A585 Windy Harbour to Skippool Improvement Scheme

7.18 Comments on Written Representations

Regulation Number:	Regulation 5(2)(q)
Planning Inspectorate Scheme Reference	TR010035
Application Document Reference	TR010035/APP/ 7.18
Author:	A585 Windy Harbour to Skippool Improvement Scheme Project Team, Highways England

Version	Date	Status of Version
Rev 0	May 2019	Deadline 3 Submission

Figure 2-1: Existing culvert shown against existing and proposed road layouts

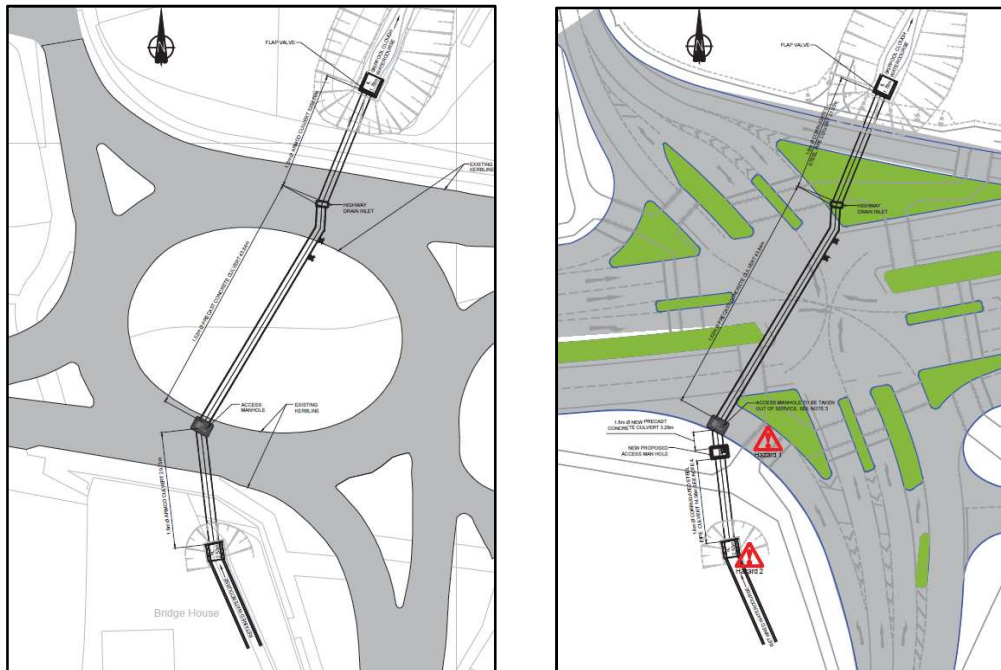
REP2-058.4	I understand that Highways England view the construction of the new junction as an opportunity to renew the infrastructure under the roundabout junction which is now forty years old. I accept the wisdom of that. However, that part of Horsebridge Dyke into which the culvert runs and which forms part of the Easterly boundary of my property is substantially in excess of forty years old and I question how it will cope with a connection to a new culvert carrying with it a significant flow of powerful tidal surges. I seek from Highways England proposals which will ensure that the construction of a new culvert under the new traffic light junction will be coupled with the construction of a two metre high fence along the top of the embankment and any further reconstruction works to make the Dyke which forms my easterly boundary secure and safe	The section of Horsebridge Dyke south of Skippool Junction is not subject to tidal waters due to the presence of a flap valve on the existing northern headwall that prevents the high tide waters from moving upstream. However, the flap valve does prevent water upstream from being discharged during those high tides. The arrangement of a tidal flap valve would be re-provided on the northern headwall of the proposed replacement culvert. Measures will be included to prevent scour and erosion at the culvert inlet and outlet and the proposed replacement culvert will include for a mechanism at the culvert outfall to prevent tidal ingress upstream along the Horsebridge Dyke. The design proposals for the replacement culvert have been reviewed and approved in principle by the Environment Agency as having no detriment to existing flood risk. A Technical Note for the new culvert is appended to the draft Statement of Common Ground with the Environment Agency (document reference TR010035/APP/8.3). A 2m high fence is not necessary.
